Harnett County Government Complex
307 W. Cornelius Harnett Boulevard
Lillington, NC 27546

Re: Status of Repair Application

### Harnett County Department of Public Health Site Sketch

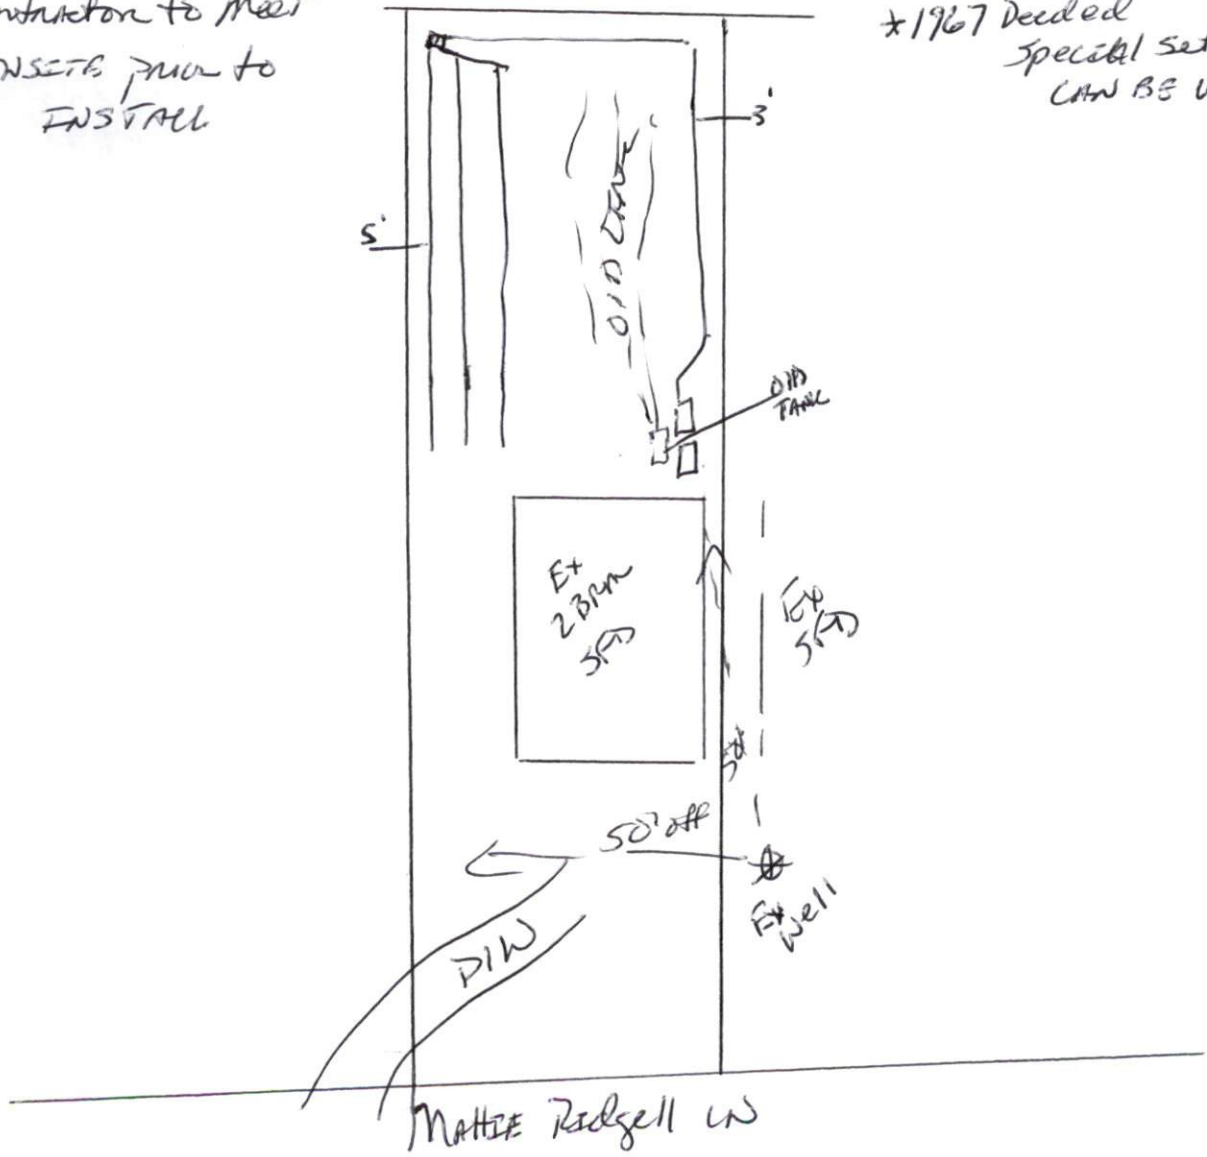
- 1. Use pink flags to mark property lines and irons that are Set by surveyor need to be visible. (\$25.00 Fee incurred)
- 2. Use orange flags to mark house box.
- 3. Directions not clear to property (*\$25.00 fee incurred*)
- 4. Property needs cleared
- 5. Driveway not shown on site plan (Revision Required)
- 6. Backhoe pits required
- 7. **Other- Property needs to be surveyed and property irons exposed.**
